ASSESSMENT REPORT

Section 75W Modification Woolworths Mixed Use Development Tweed Coast Road, Cabarita Beach MP07_0179 MOD 4

drawing title  
**SITE PLAN**

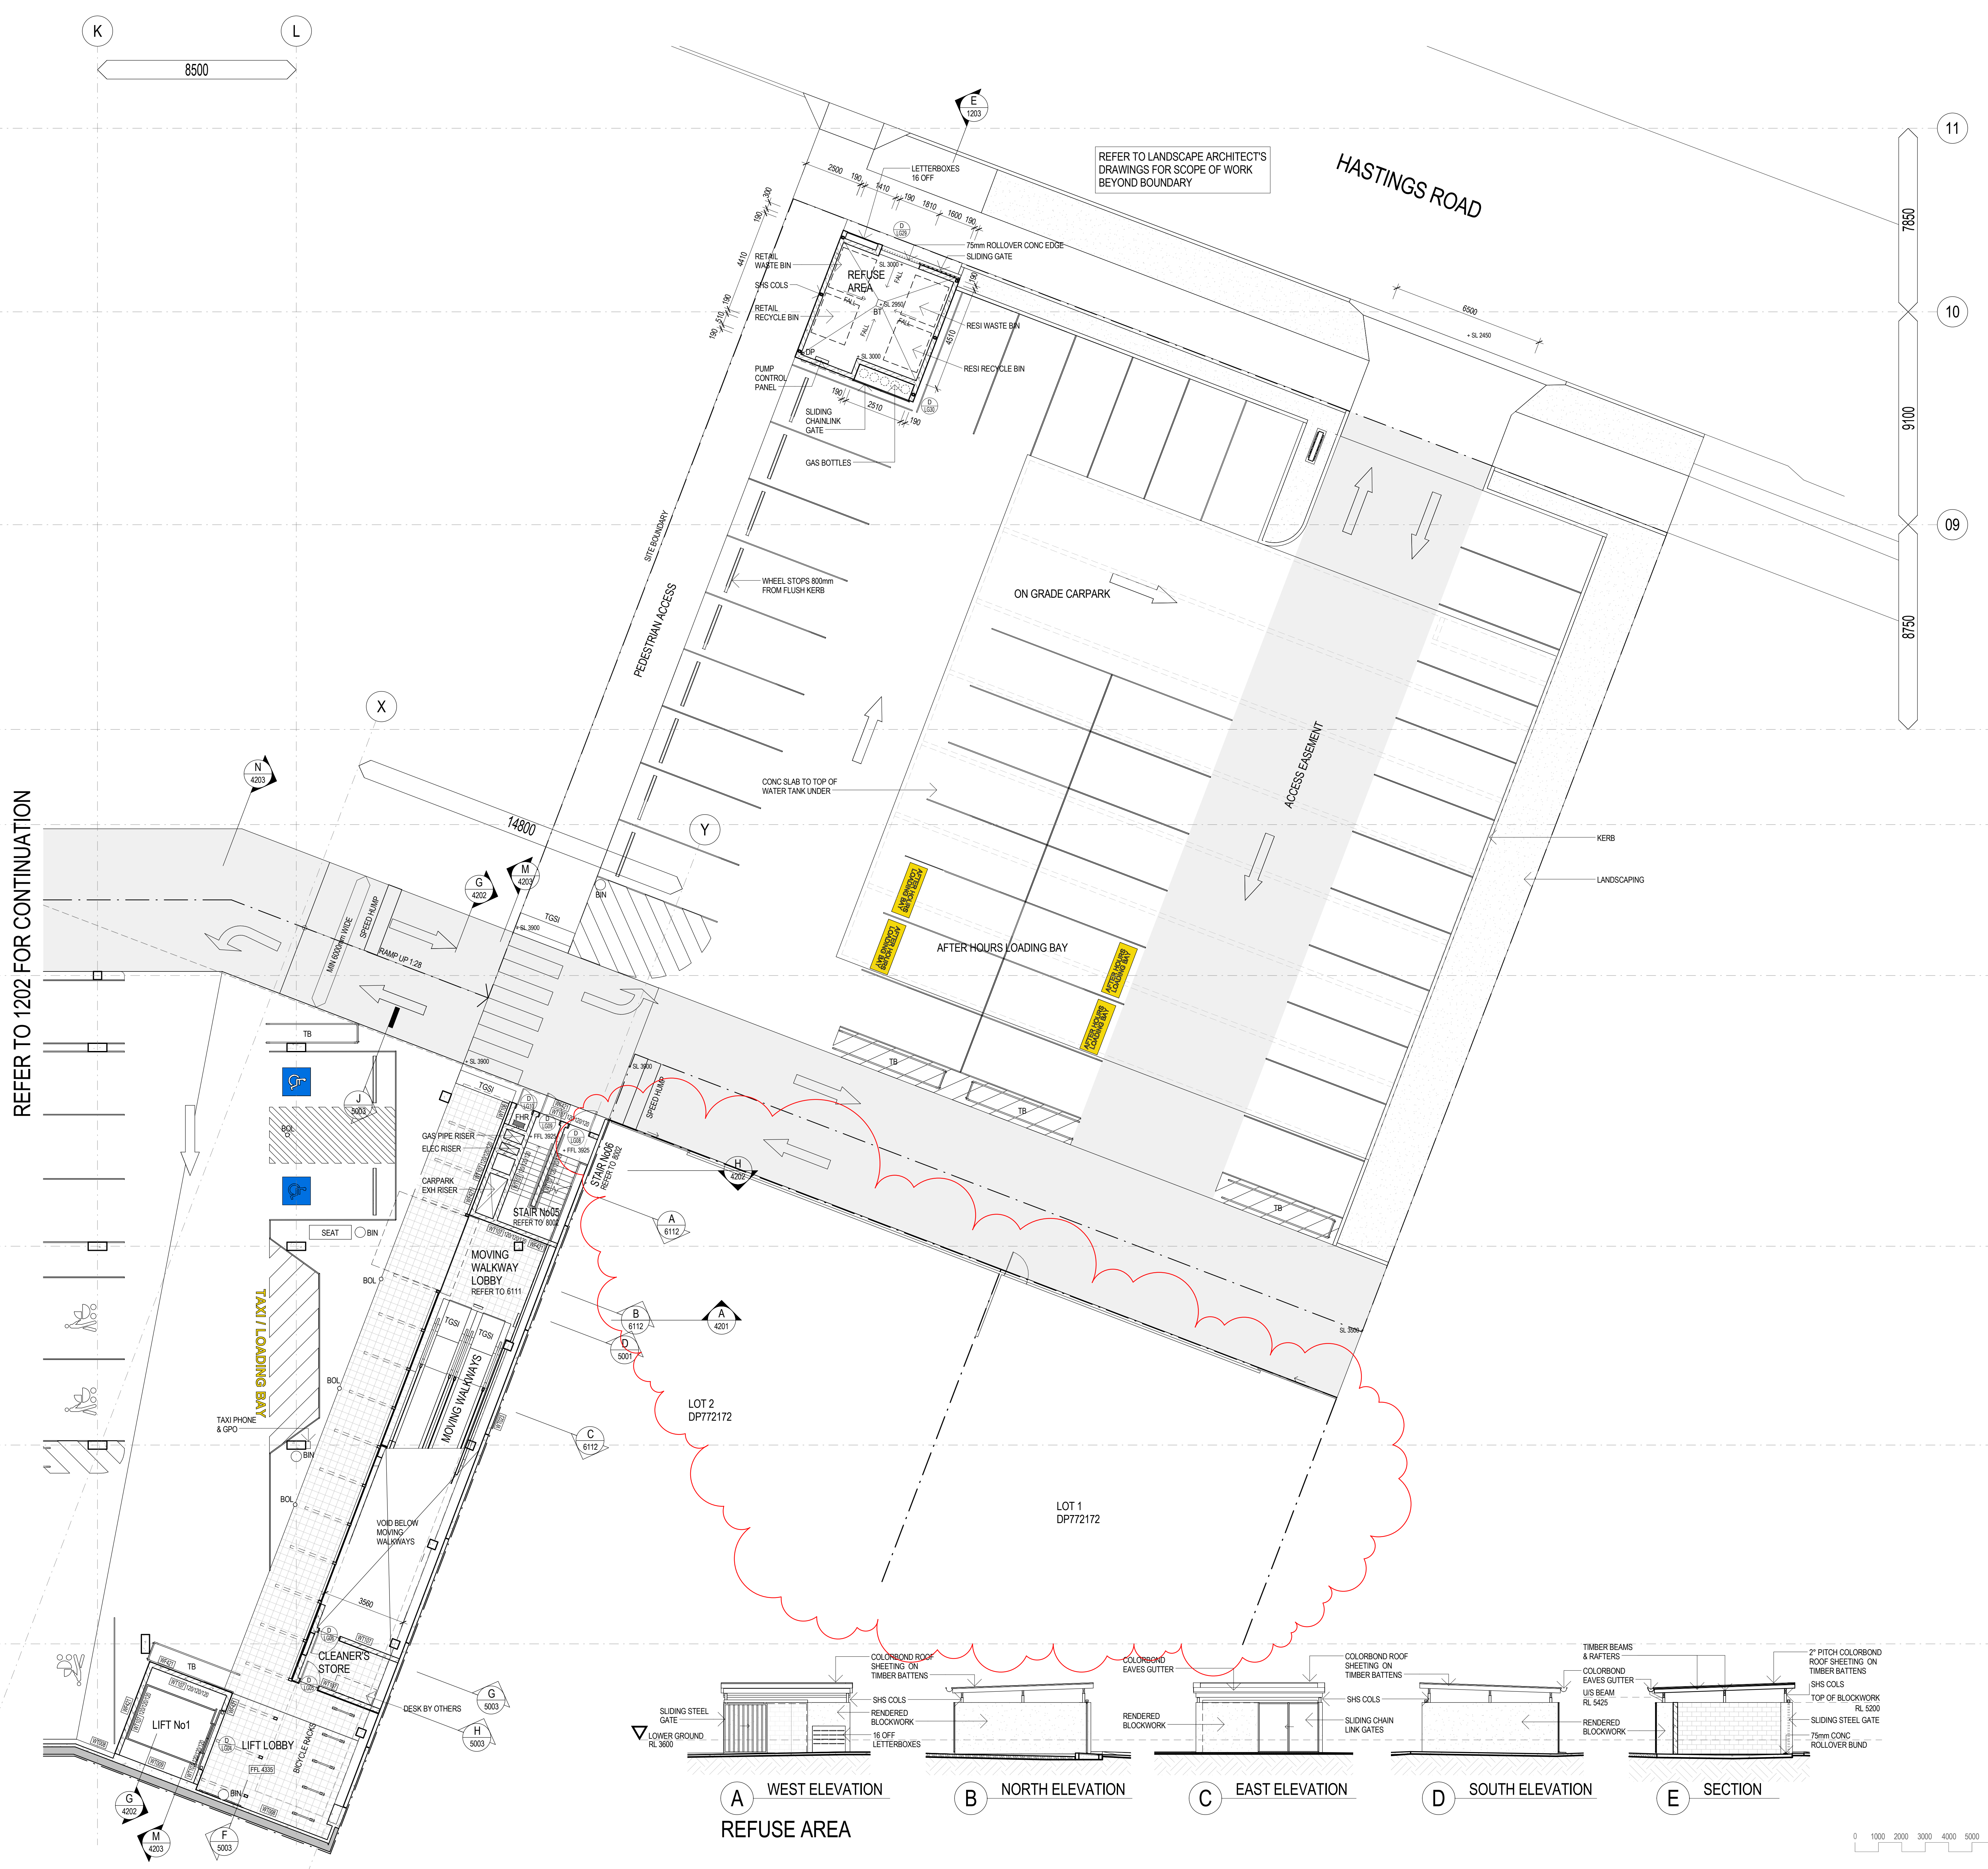
The plans approved under MOD 1 identified that a future laneway will be constructed over the rear portions of lots 1 and 2 in DP 772172 and lots 188, 189 and 190 in DP 259164. Approved drawing DA – 01 Rev A is shown in **Figure 4**. The relevant lots are highlighted in light blue while the project area is outlined in red.

The rear portions of lots 188, 189 and 190 in DP 259164 are affected by an existing 3 m wide right of carriageway. Condition B22(4) requires the construction of a 3 m wide laneway 'adjacent' to lots 188, 189 and 190 in DP 259164 but does not specify the construction of laneway over these lots and lots 1 and 2 in DP 772172 despite this being depicted on the stamped plans.

The Department believes that under the circumstances it is necessary to amend the approval to include lots 1 and 2 in DP 772172 and lots 188, 189 and 190 in DP 259164 in the project area in Schedule 1, Part A - Table. Further, the Department also considers that it is necessary to amend Condition B22(4) by inserting the words, "together with the 3 m wide section of laneway over the rear portion of lots 188, 189 and 190 in DP 259164", after the existing wording, "the 3 m wide section of laneway adjacent to lots 188, 189 and 190 in DP 259164".

**LOWER GROUND**  
**LEVEL PART B**  
**FLOOR PLAN**

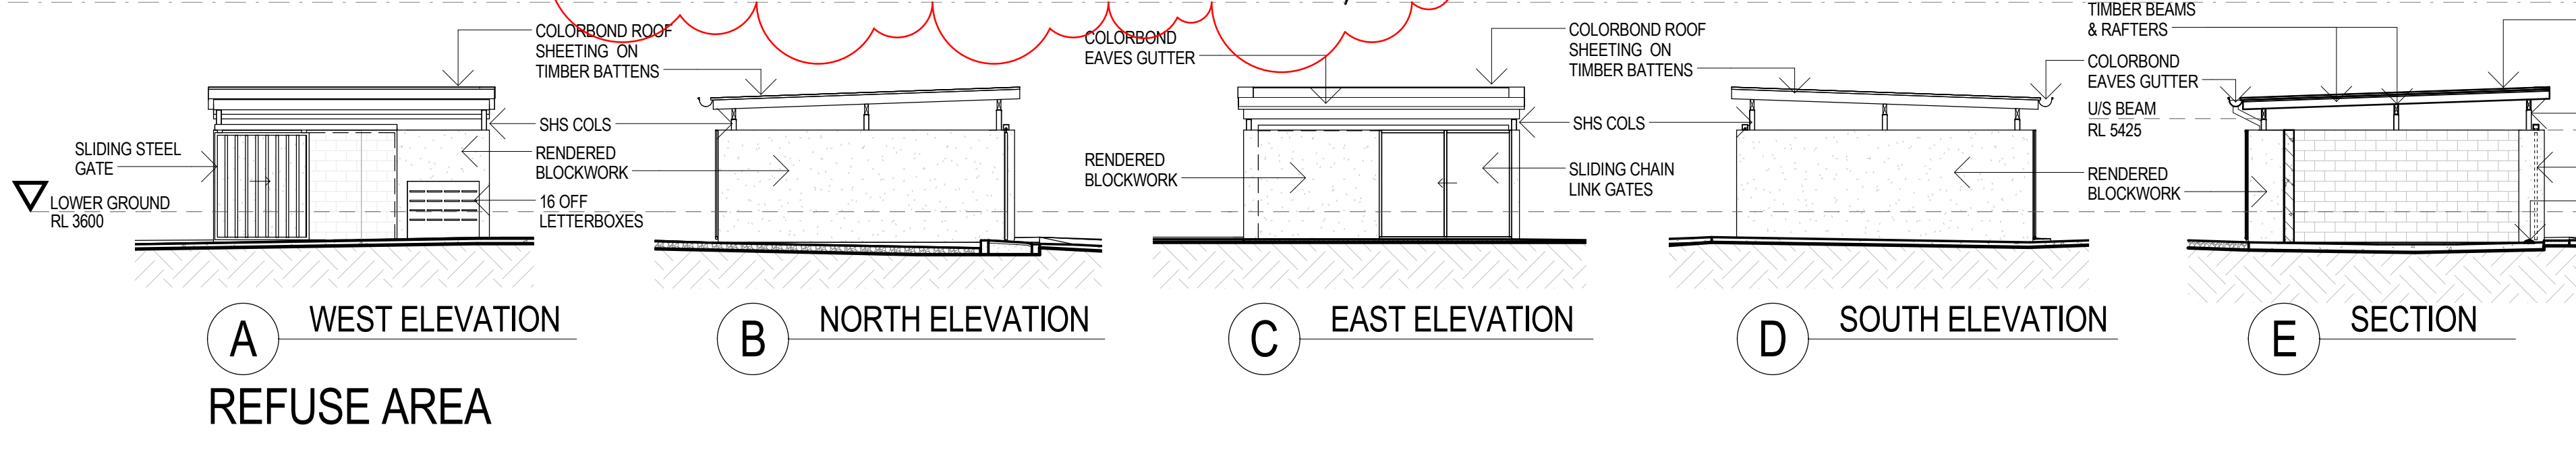
Council also noted that the application seeks approval to relocate the "after hours loading bay" from the at grade car park to the basement car park and has requested that the Department consider the impacts of this modification. This issue is discussed in greater detail in Section 6 of this report.

The modification involves the relocation of the After Hours Service Vehicle Loading Bay from the at grade car park to the lower ground floor (basement) car park. This will result in an improvement of the environmental performance of the approval as the potential for unreasonable noise impacts to any nearby sensitive receivers from the operation of the loading bay would be mitigated by the enclosure of the proposed basement level location.
